# PORTLAND MAINE

August 25, 2005

RE: Carriage Lane Development  
ID #2003-0004, CBL #341-G-006

The following is a list of items that need to be completed for the above-stated project. This list was originally generated in two e-mails dated July 6, 2005, and is supplemental to the City's Public Works Department's list. One additional item has been added as a result of yesterday's site meeting. This is being provided for your records, and no update or response is necessary at this time.

Subdivision Plan	
CARRIAGE LANE	
Carriage Lane	
Portland, Maine	
MADE FOR	
Broadway Development	
Portland, Maine	
JOB# 99057	DATE: 06/24/99
BOOK# 678 & 658	SCALE: 1"=50'
DISC#	
FILE# 7908

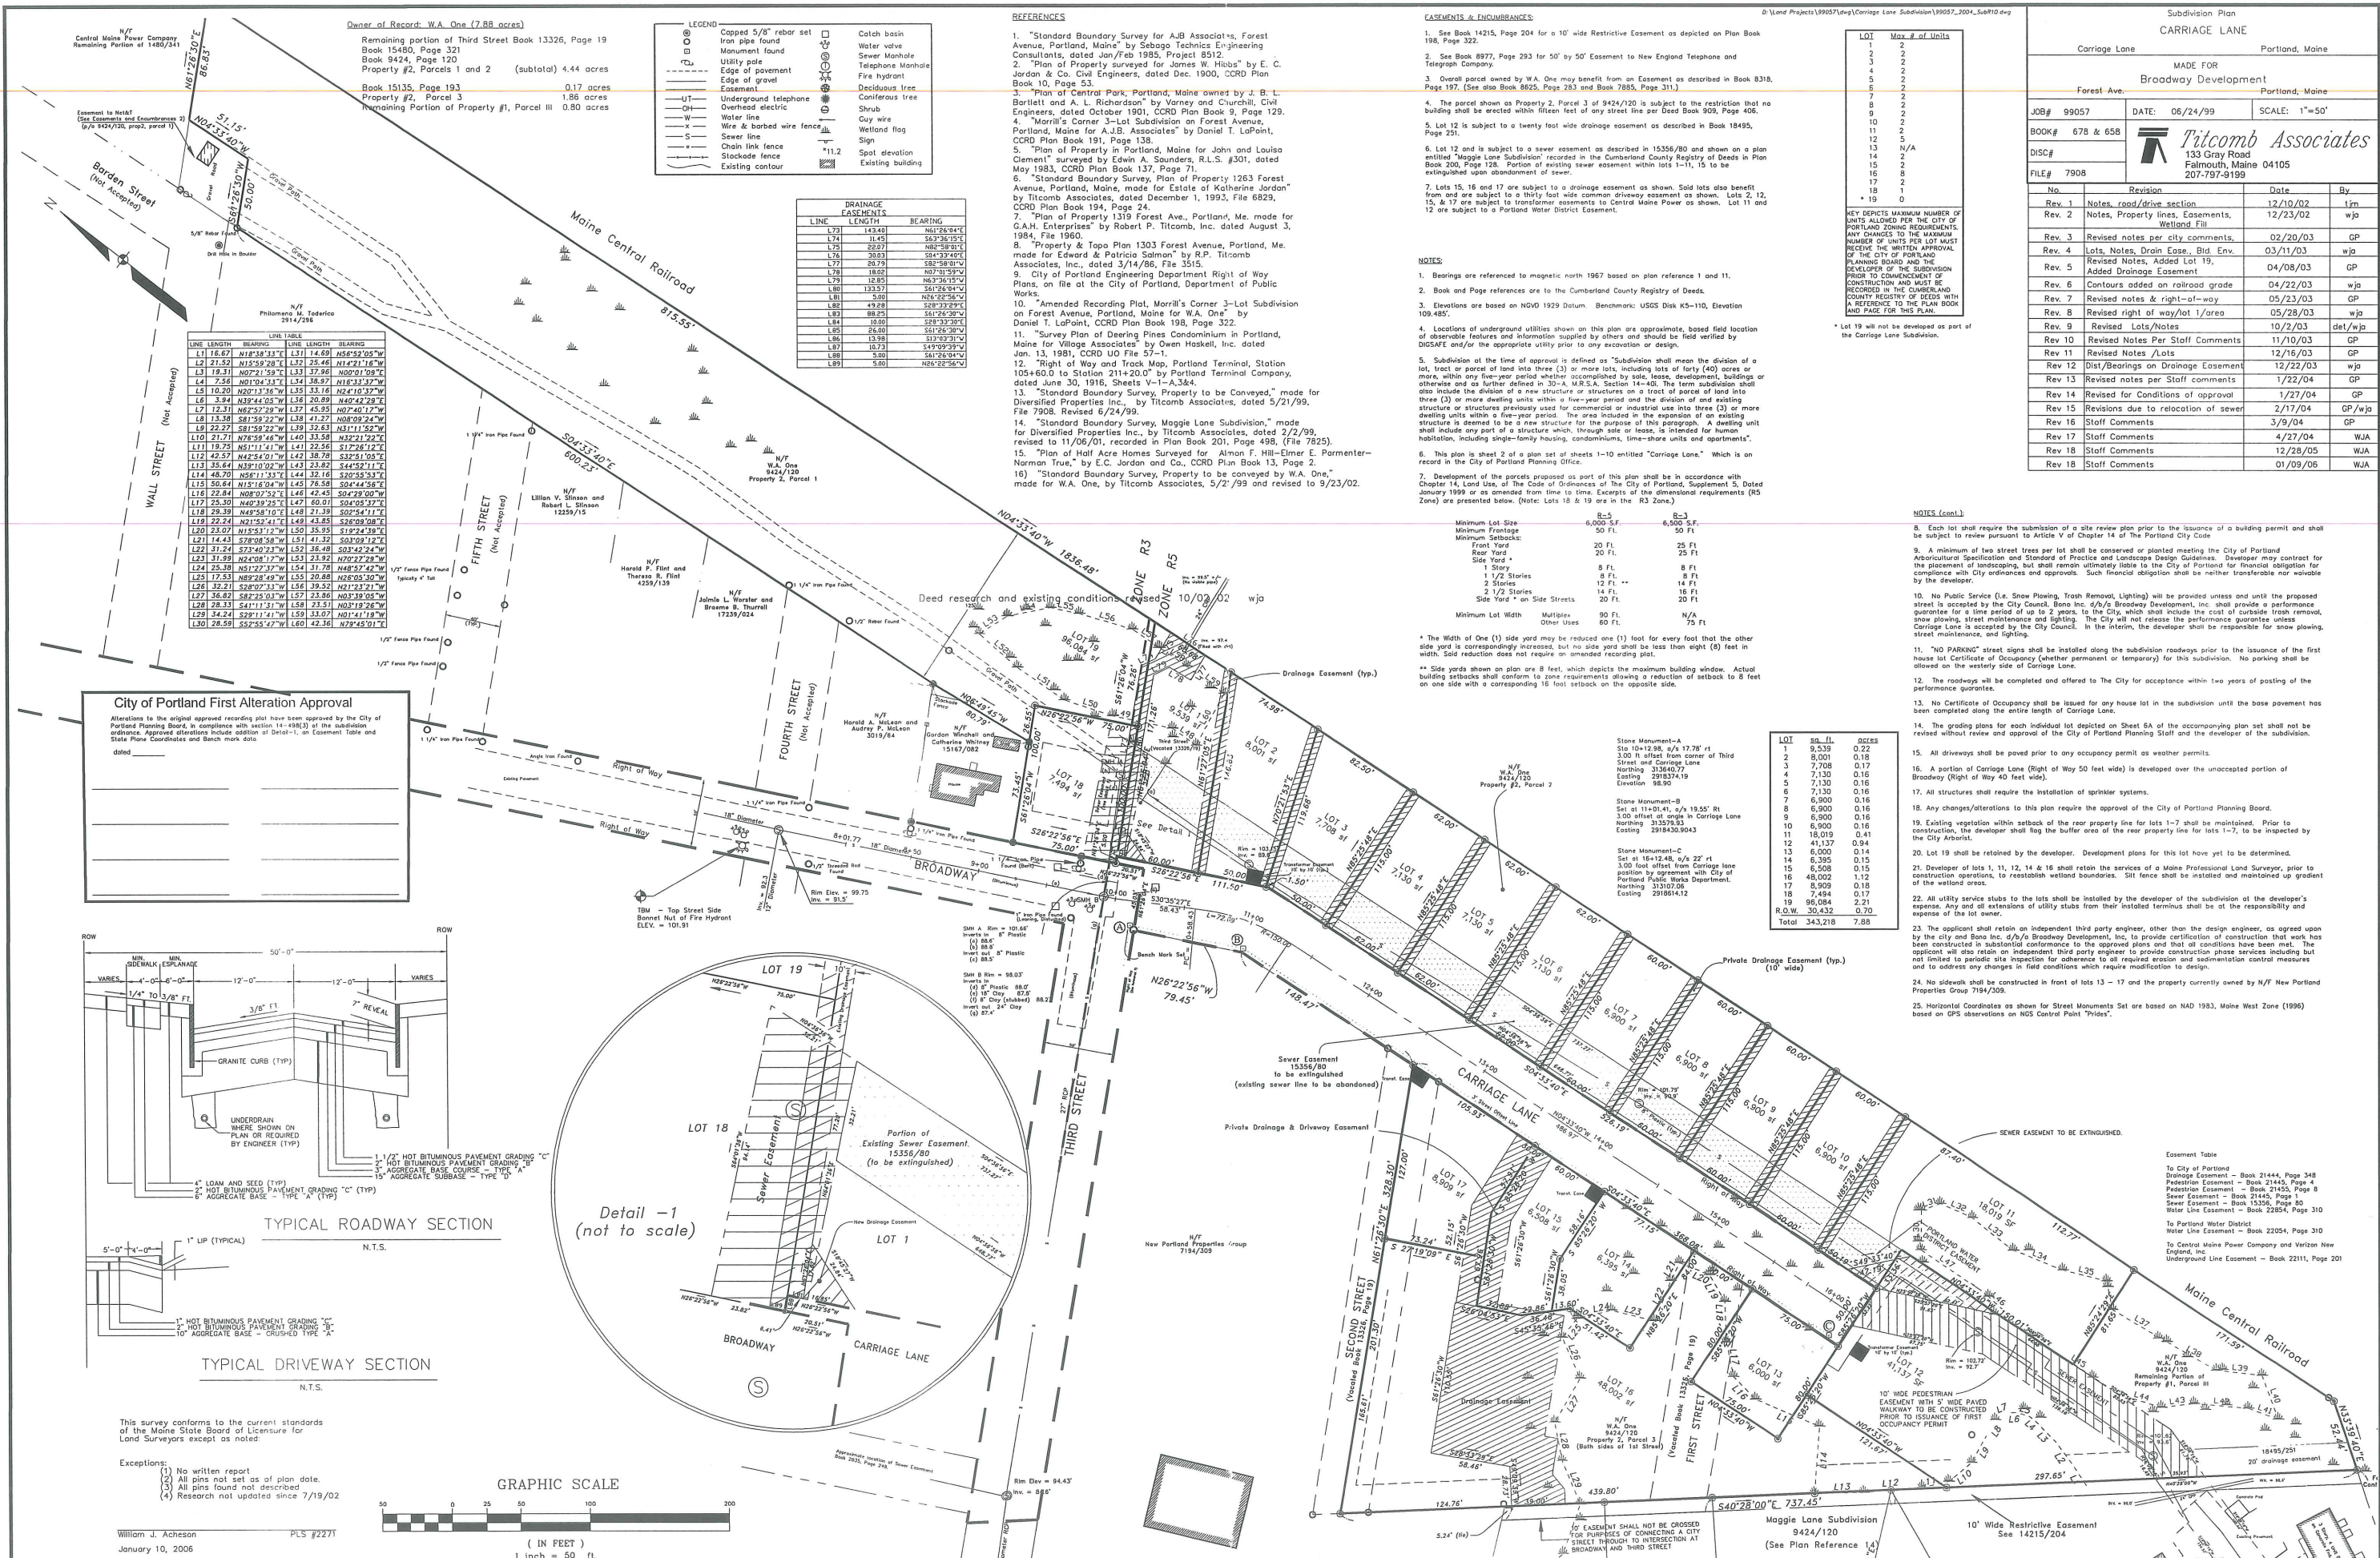
1. Confirmation that lot 13 has been deeded to the City and an executed copy has been provided.
2. Easements, public and private, need to be conveyed to the lot owners, City, Lot 22, etc.

3. Iron pins at the lot corners need to be set/reset.
4. Lots 1,2,3, and 12 need to be stabilized per City and Maine DEP guidelines.
5. Silt fence can be removed in areas where sufficient grass growth has been obtained.

Drawing No.
6

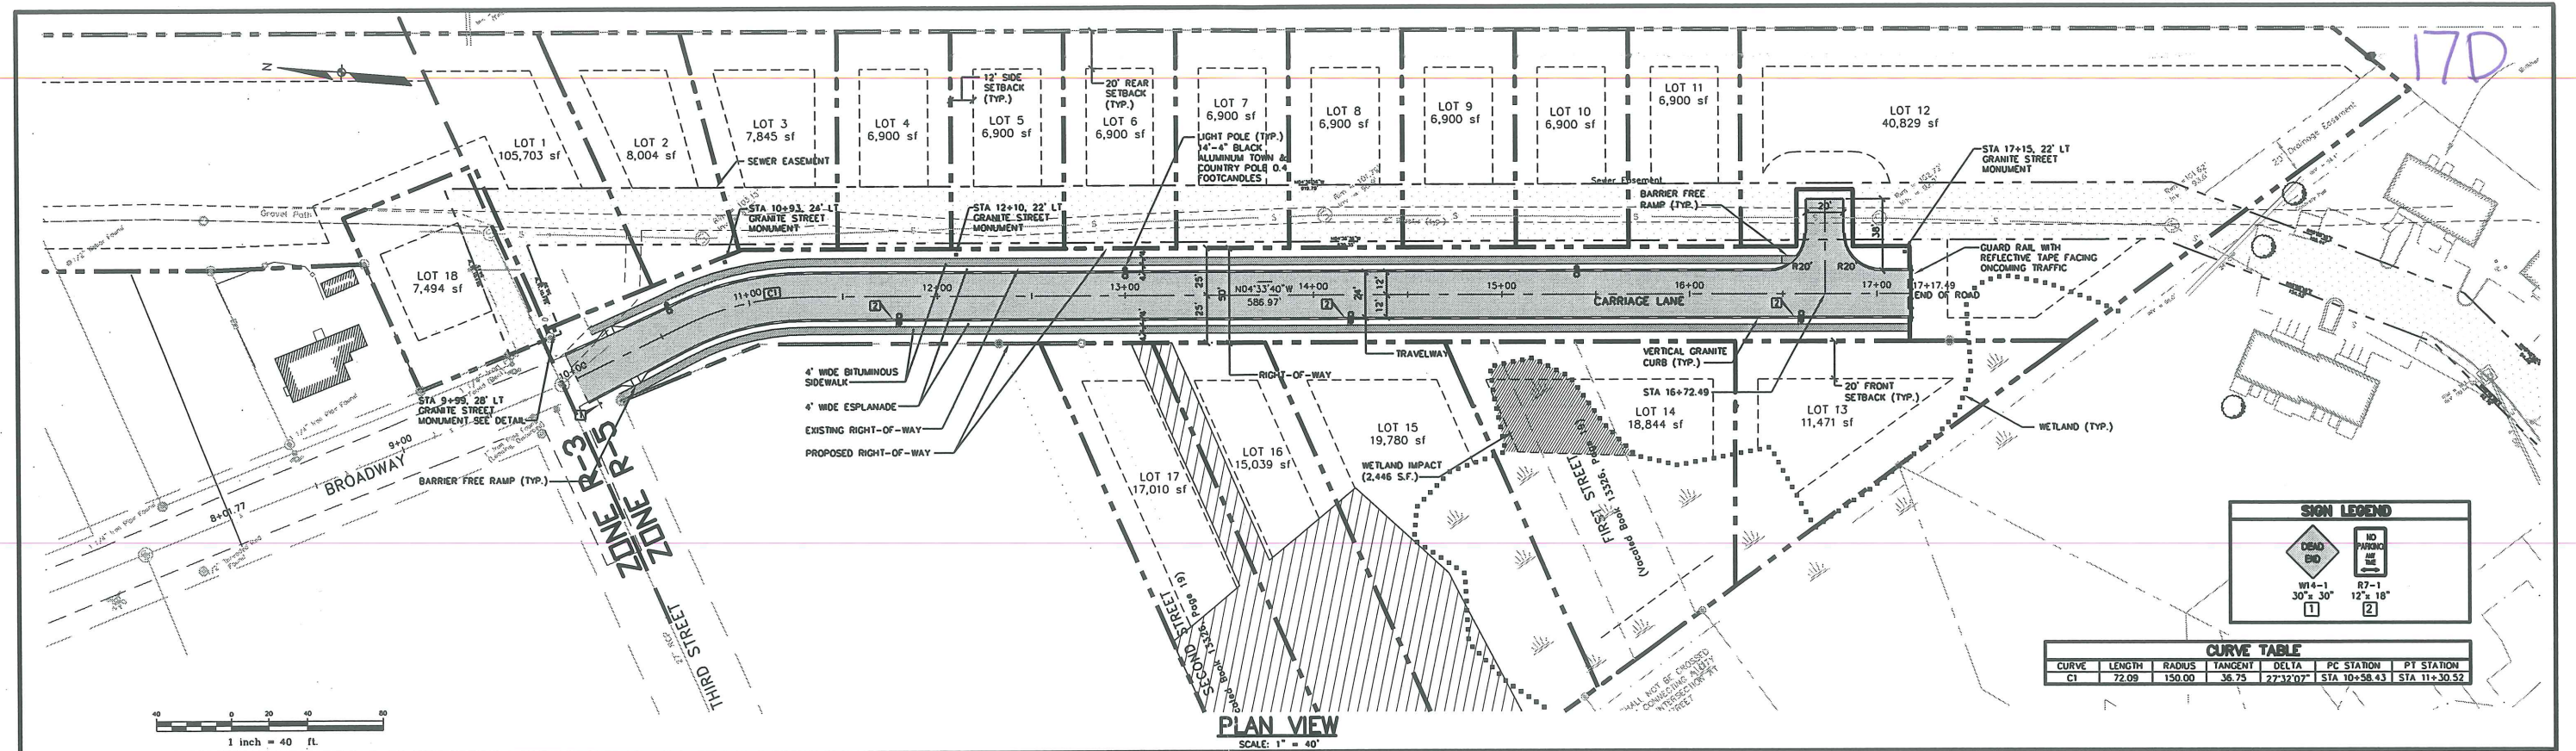
6. Amendment to plan (piping/swale between lot 1 and lot 18) has not been reviewed and approved by the City. This will need to be finalized. Also, this has not been inspected due to the lack of approved plans. An inspection will be forthcoming once it is approved.

Drawing Name:	Existing Sewer Plan & Profile
Project:	CARRIAGE LANE
Client:	BROADWAY DEVELOPMENT P.O. Box 10127, Portland, Maine 04104

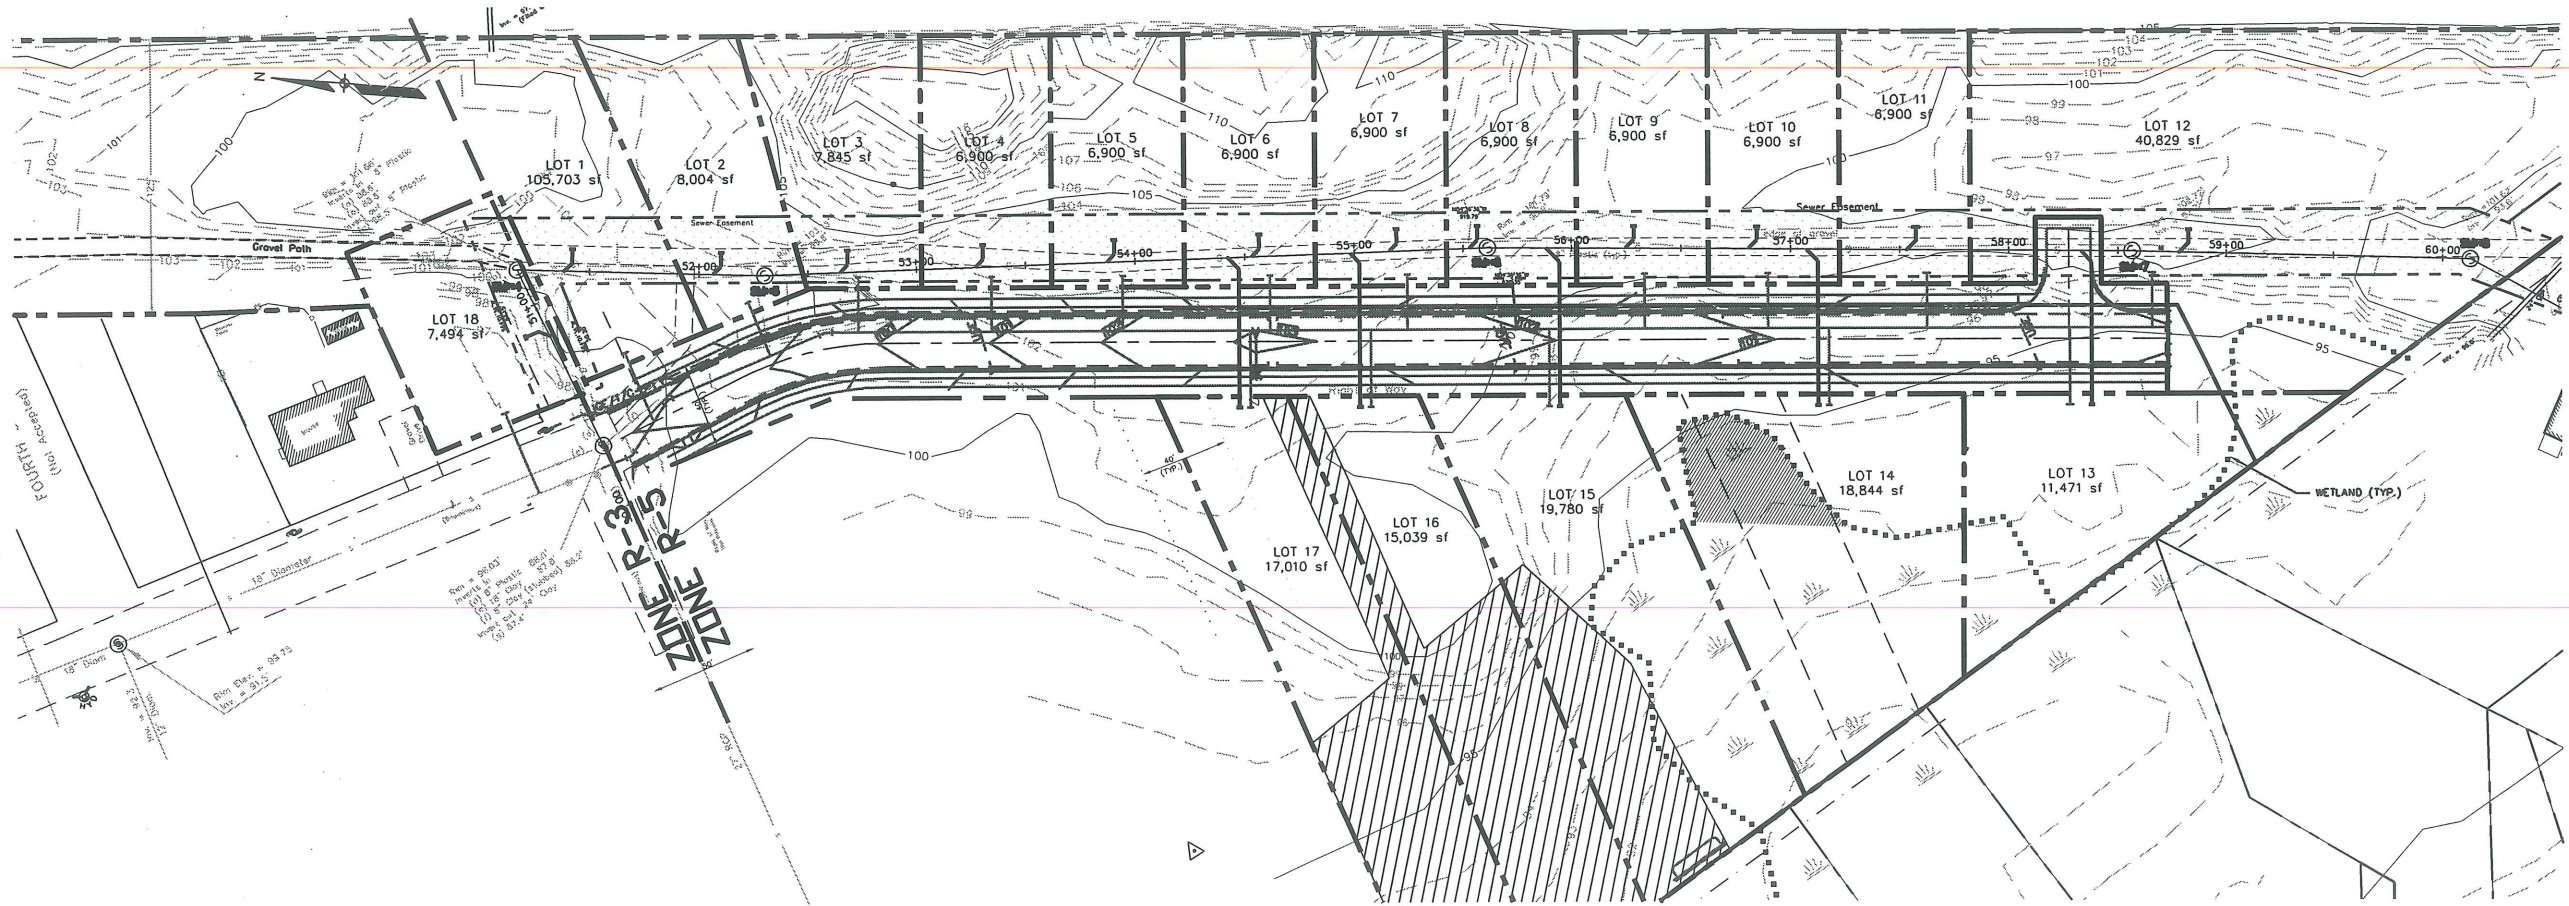
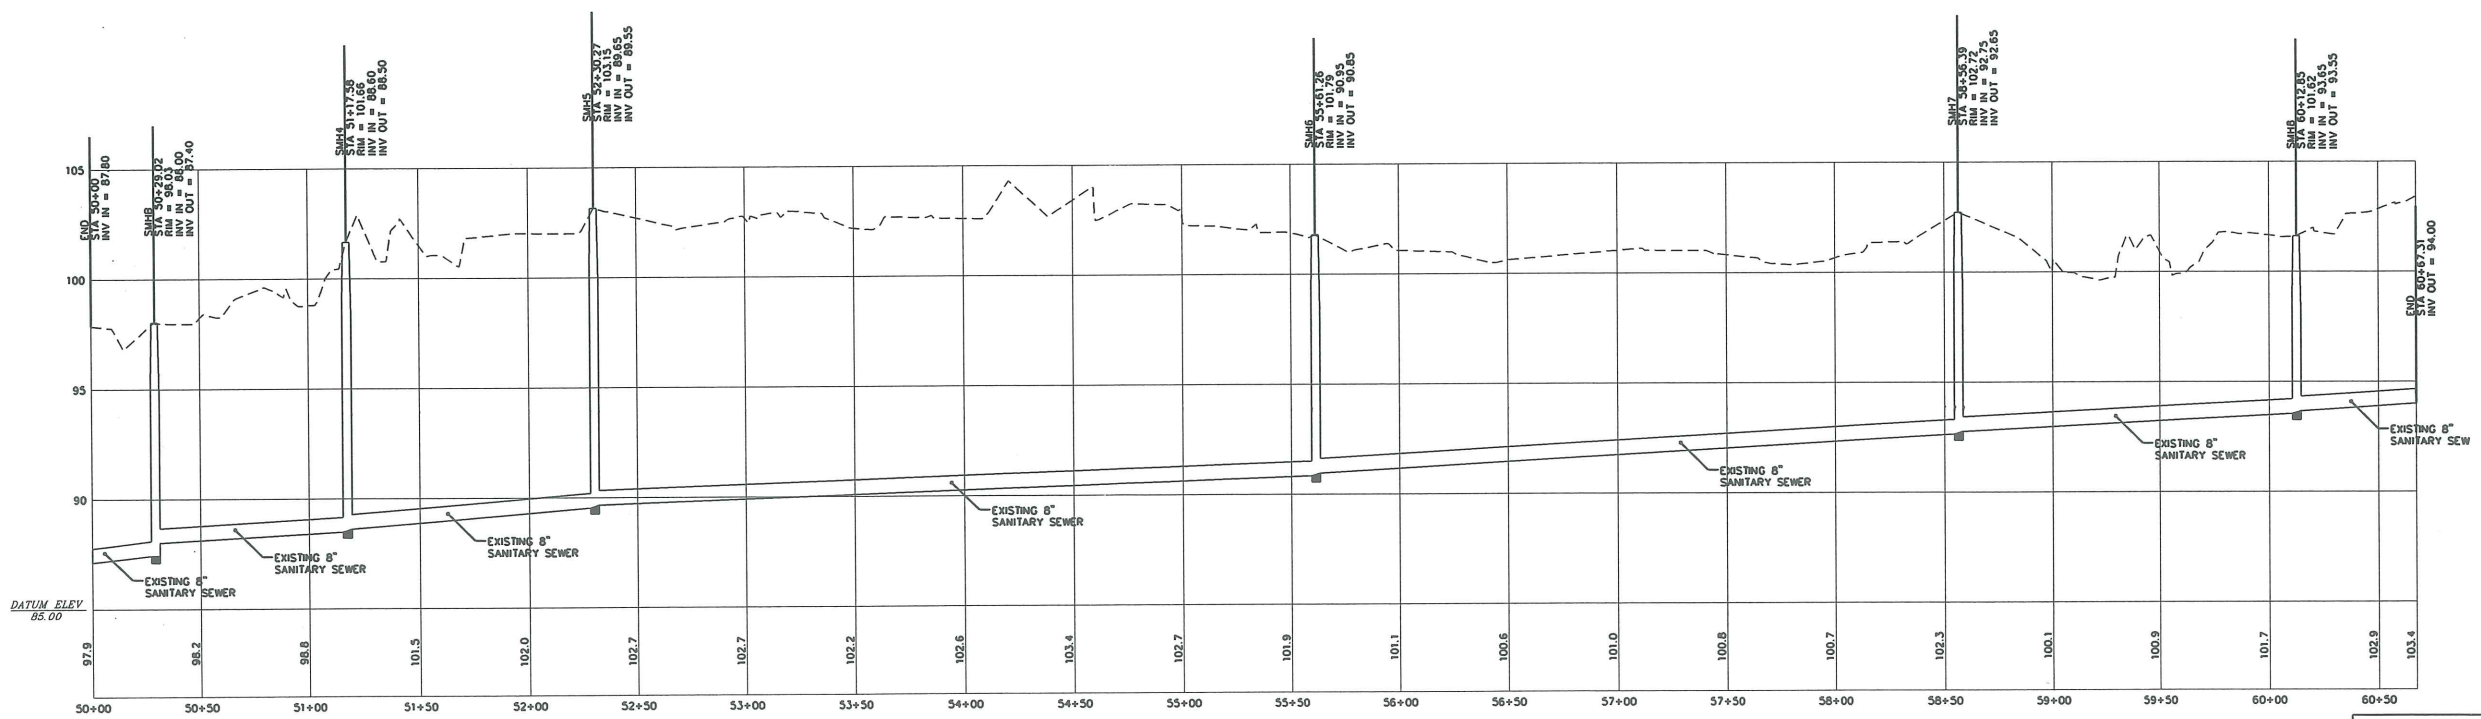
7. The sewer manhole on lot 12 needs to be lowered as noted on the plans. This will be a requirement of the buildout of lot 12.
8. Wetland encroachment on lot 11 needs to be restored to it's original state. Site shall conform to approved plans. This will be a requirement of the completion of lot 11.
